**Addendum No. 1**

RE: Contract ID C202339

**Watauga, Avery Counties (R-2710)**

NC-194 From Avery/Watauga County Line To Valle Crucis in Watauga County

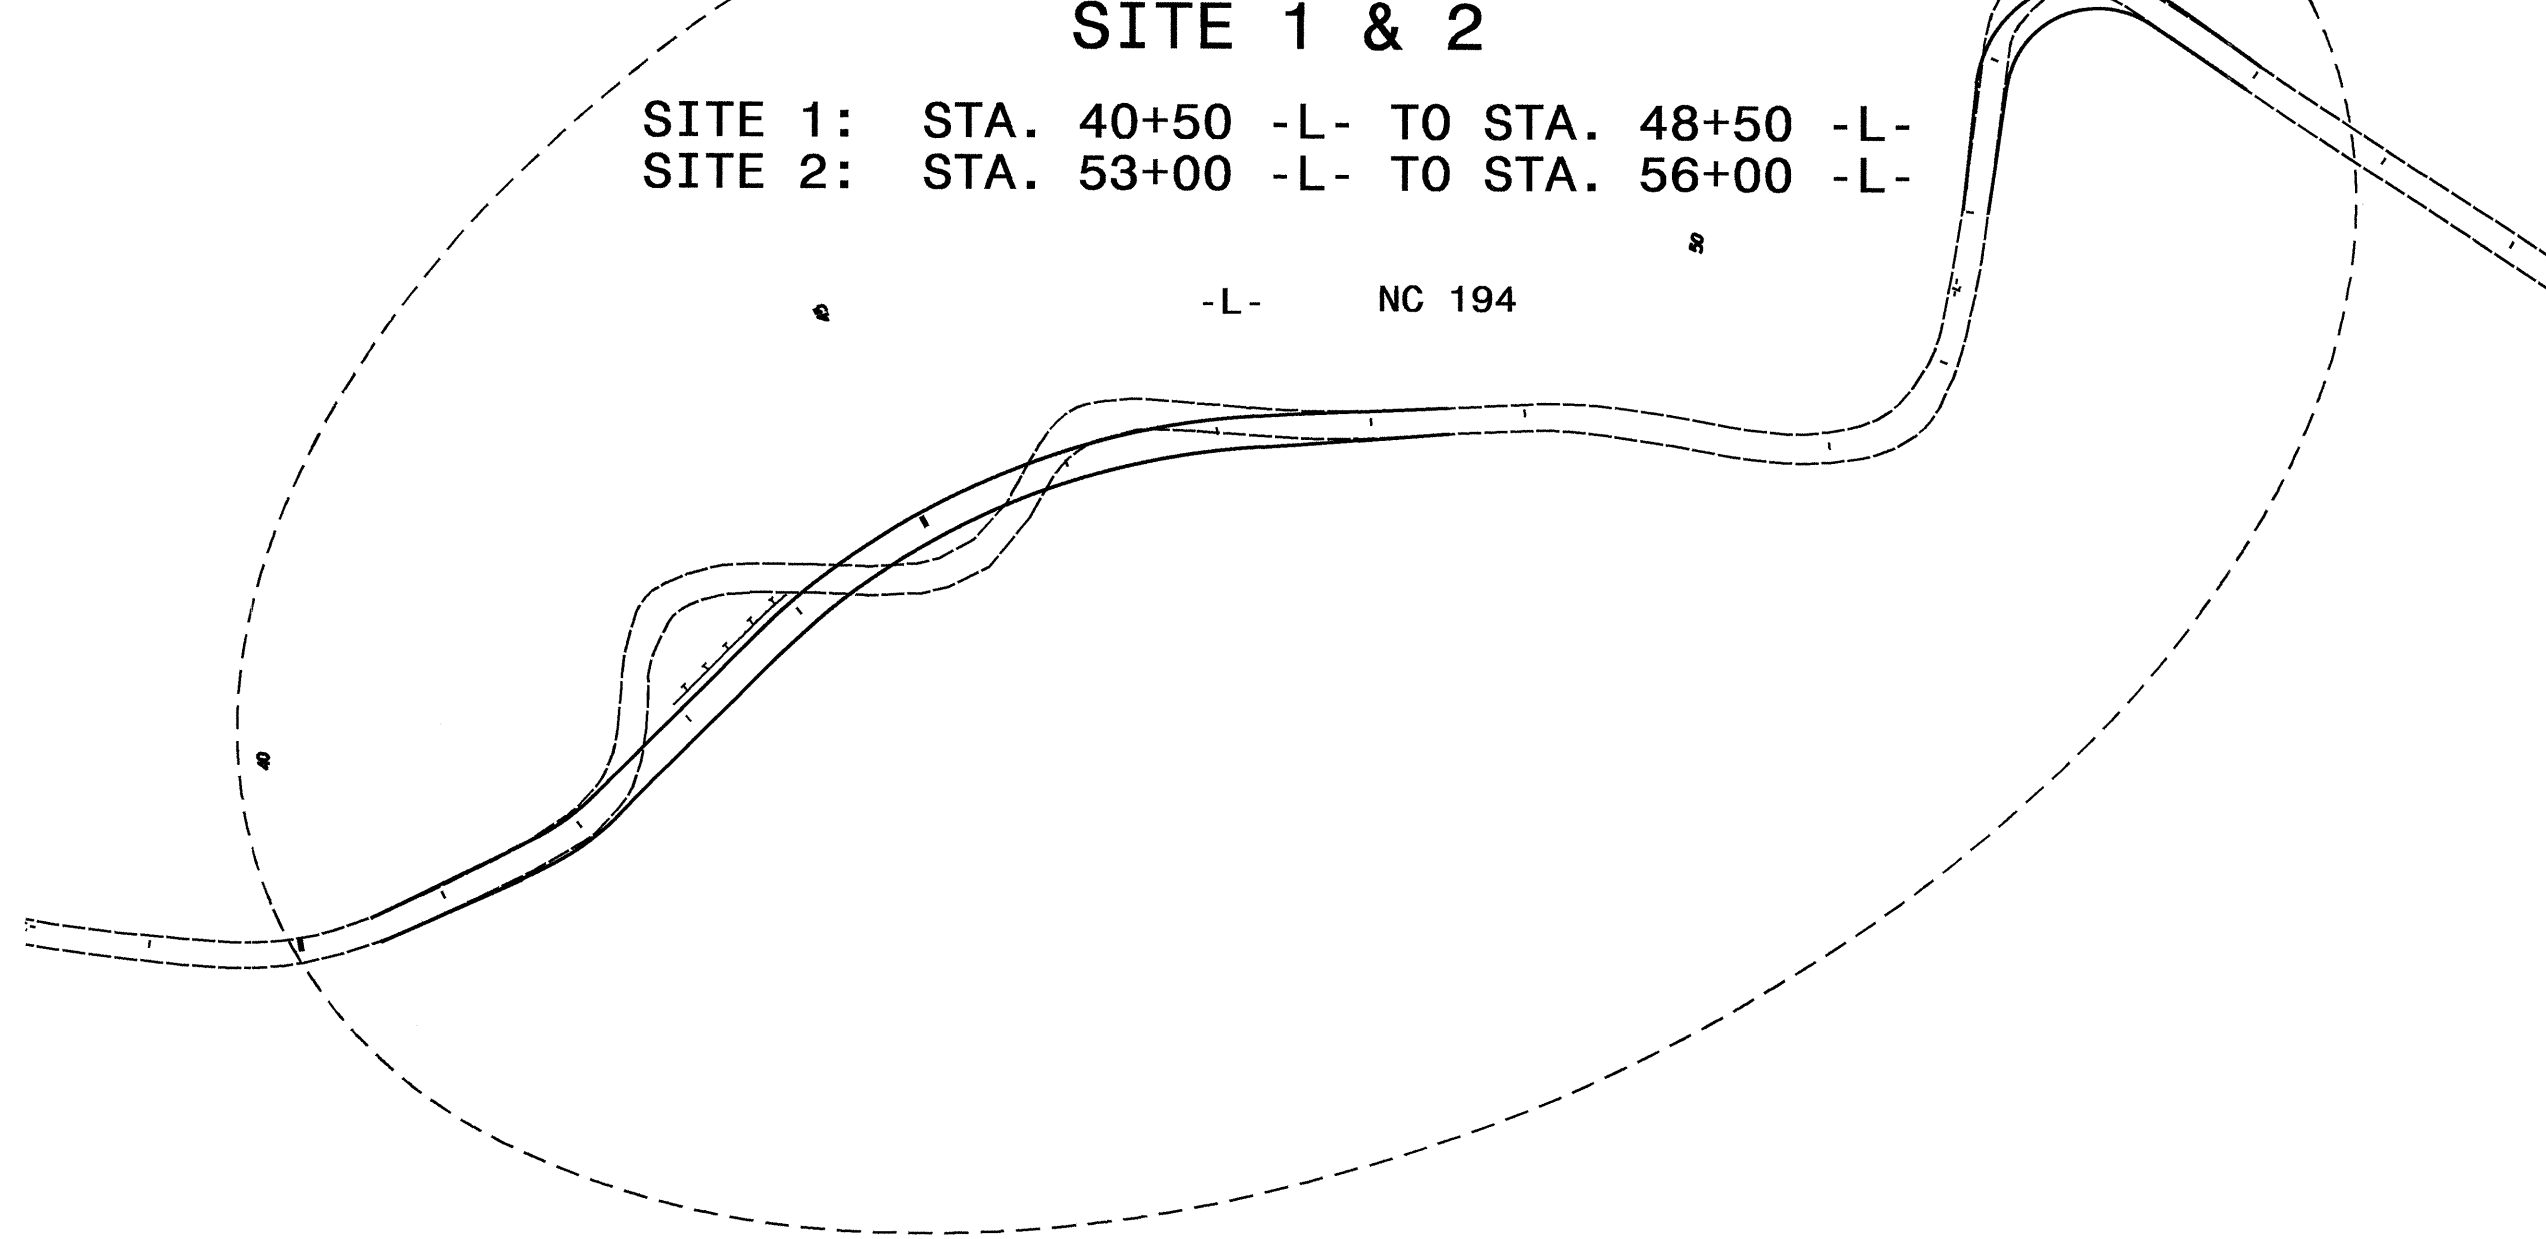
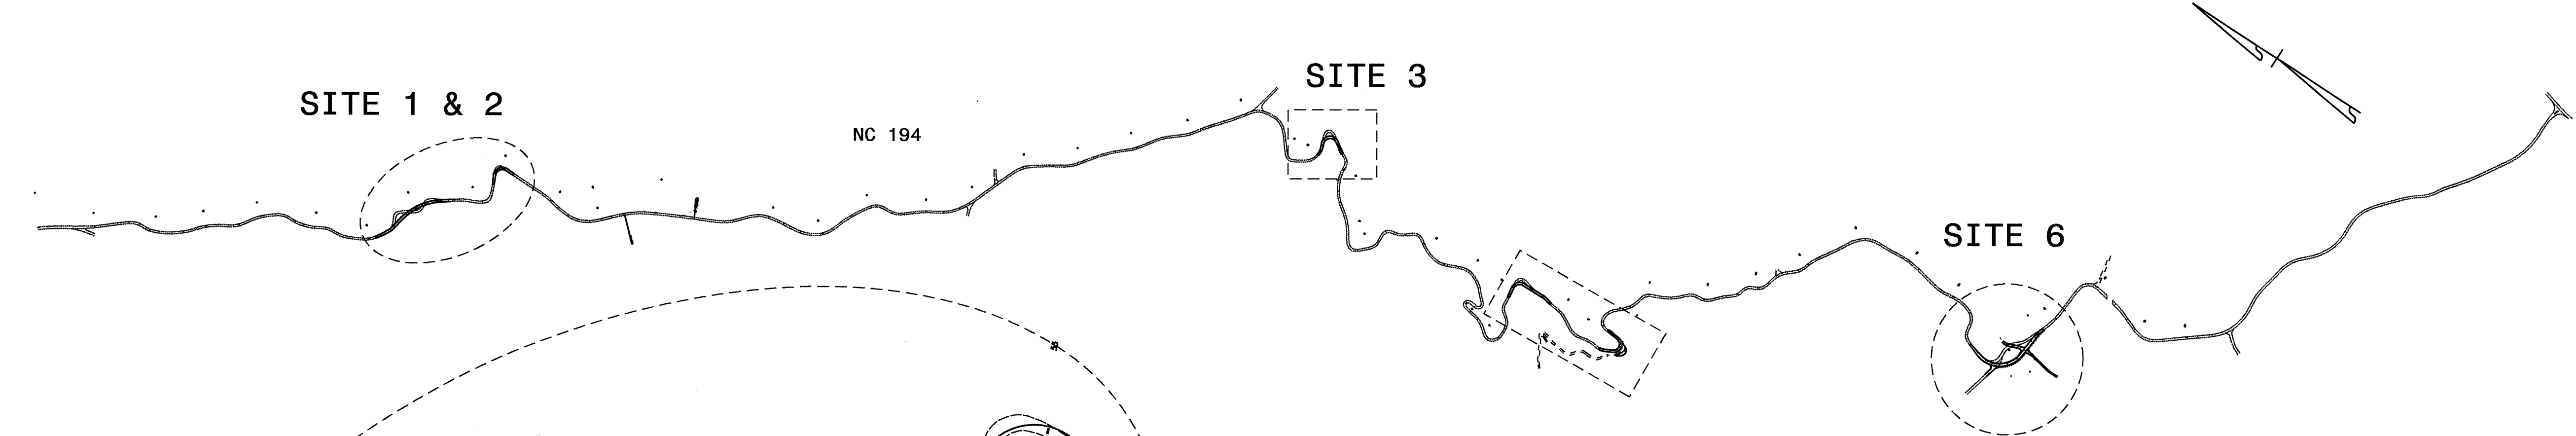
On Sheet No. TCP-2 the holiday lane closure restrictions have been revised. Also on Sheet No. TCP-2 Local Note No. 1 has been revised. Please void Sheet No. TCP-2 in your plans and staple the revised Sheet No. TCP-2 thereto.

APPROVED: _____ DATE: 6/2/10	SITE 1 & 2, STEP 3 OFFSITE DETOUR		REVISIONS	
SCALE: NONE	DATE: 05/09			
DWG. BY: DAH	DESIGN BY: DAH			
REVIEWED BY: JWW

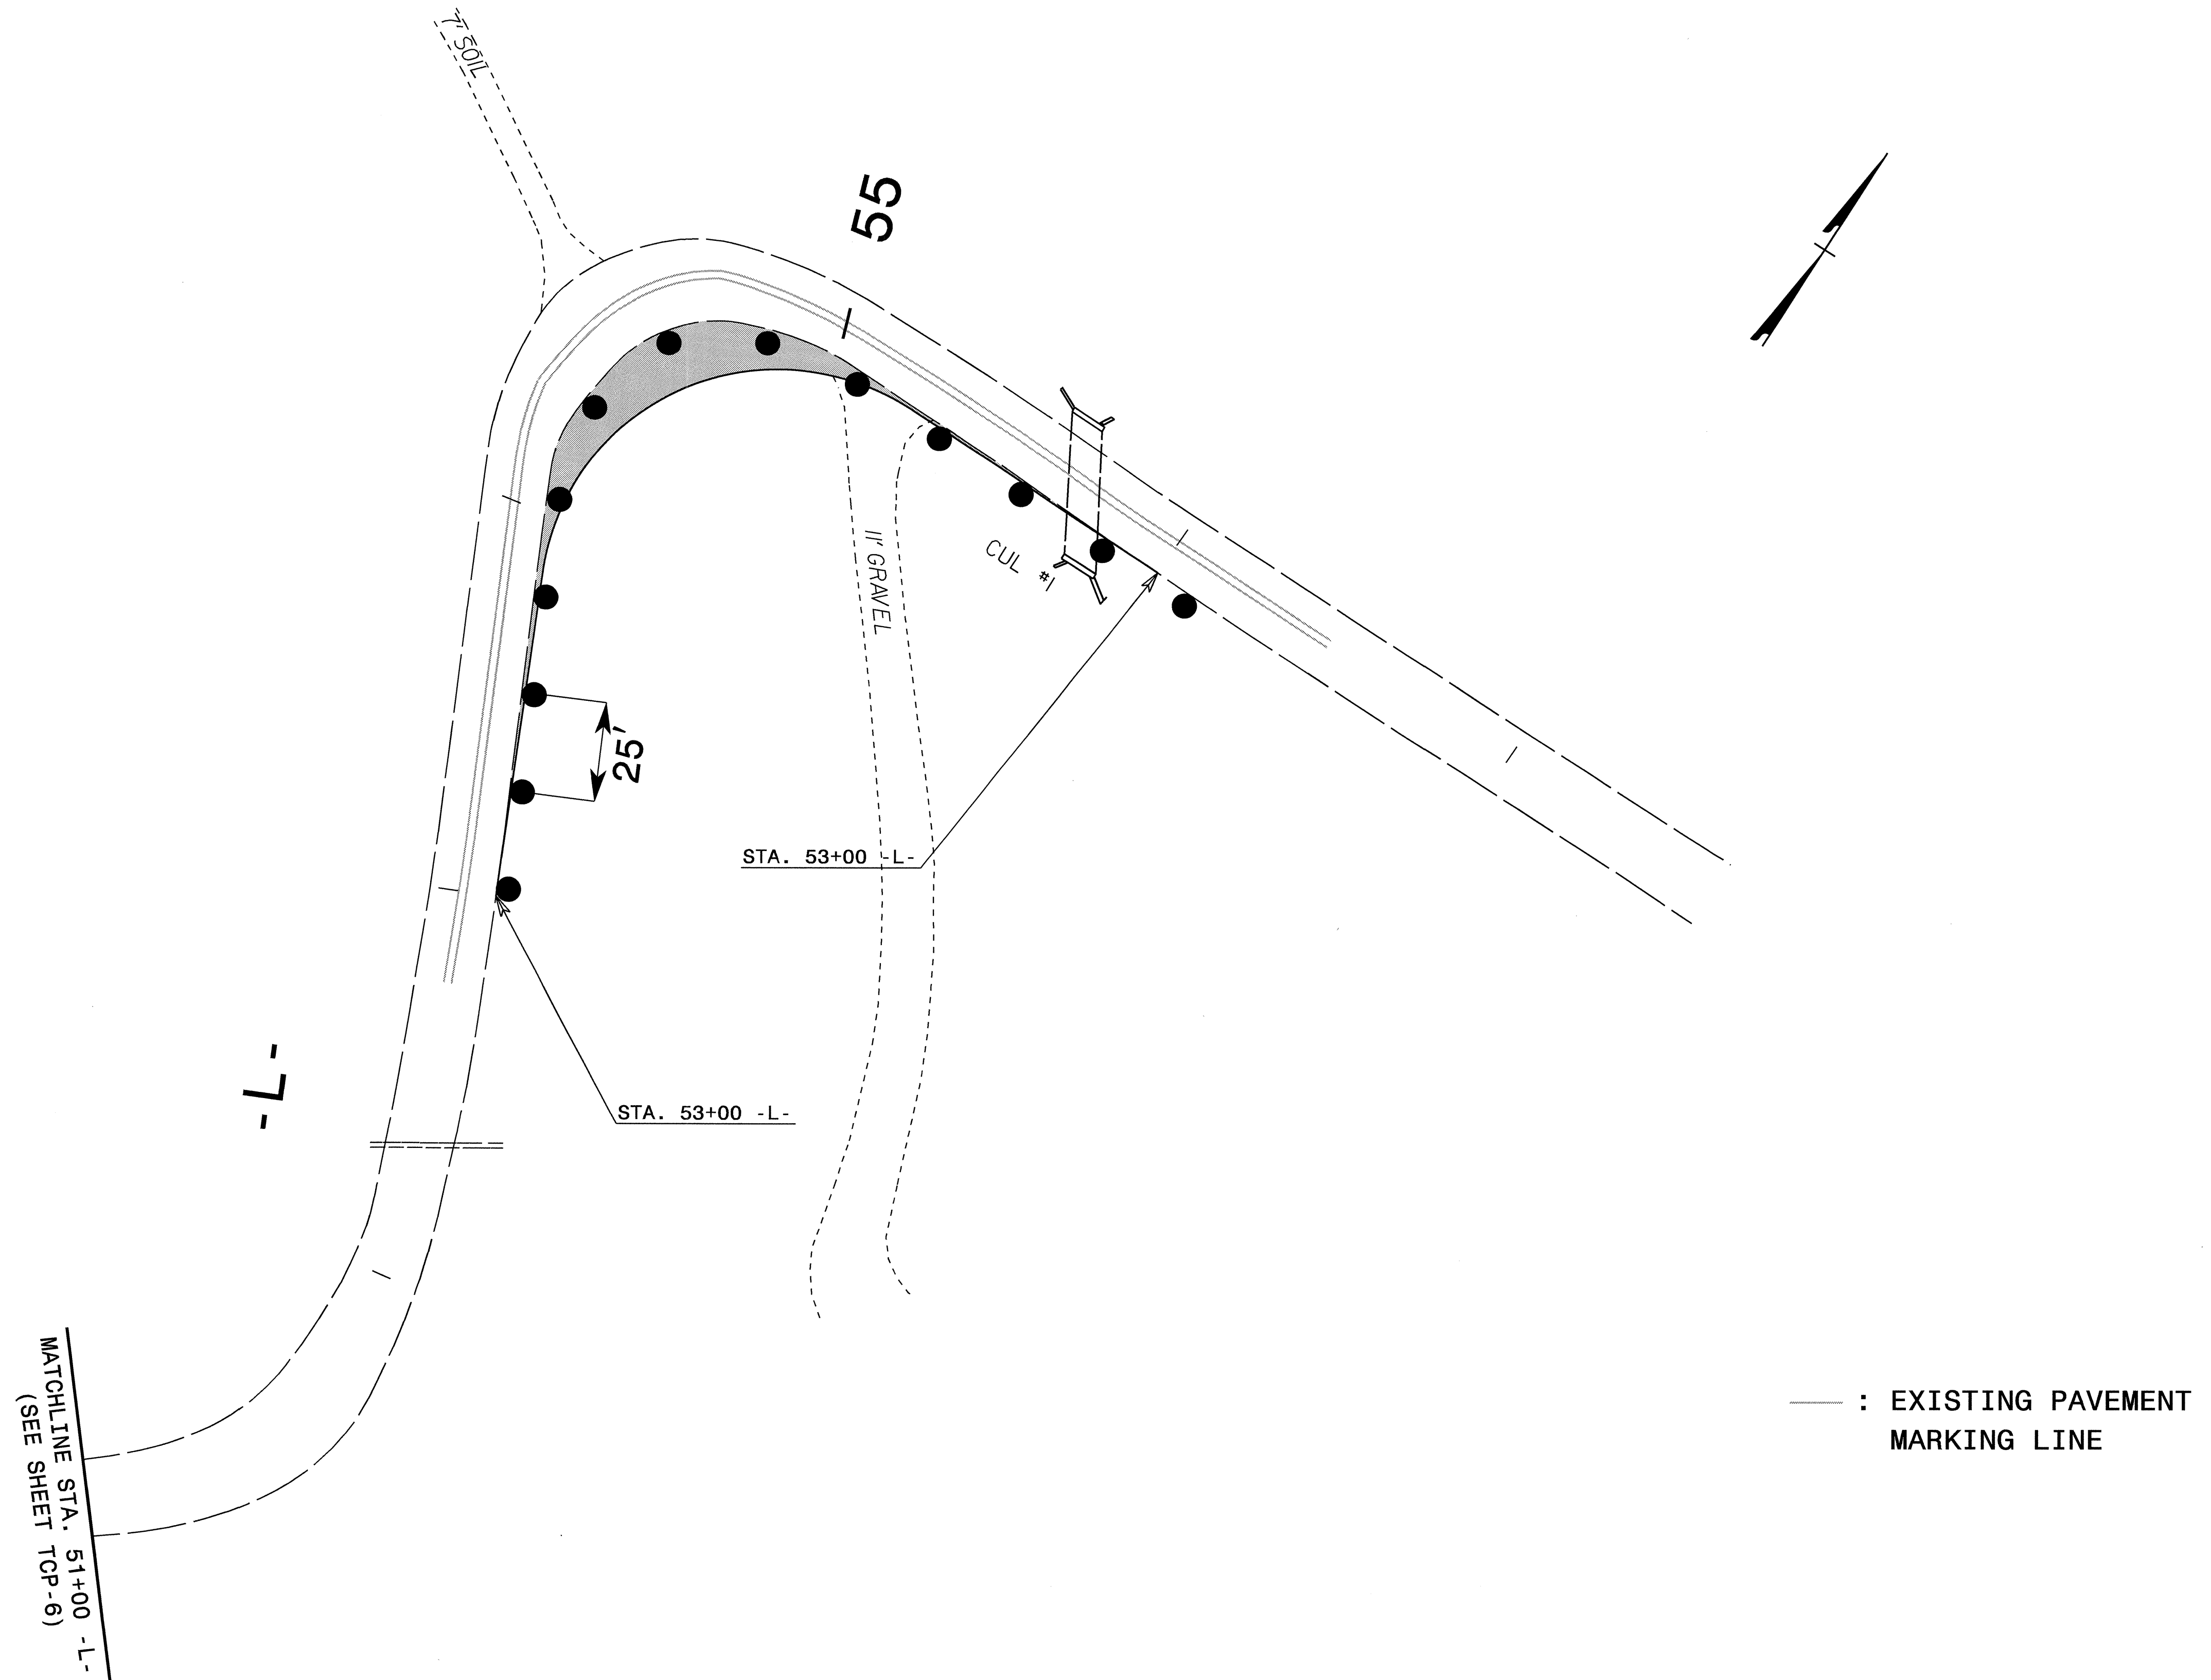
On Sheet No. TCP-3 the number of days to complete work at Site 1 Step 3 and Site 2 Step 3 has been revised. Please void Sheet No. TCP-3 in your plans and staple the revised Sheet No. TCP-3 thereto.
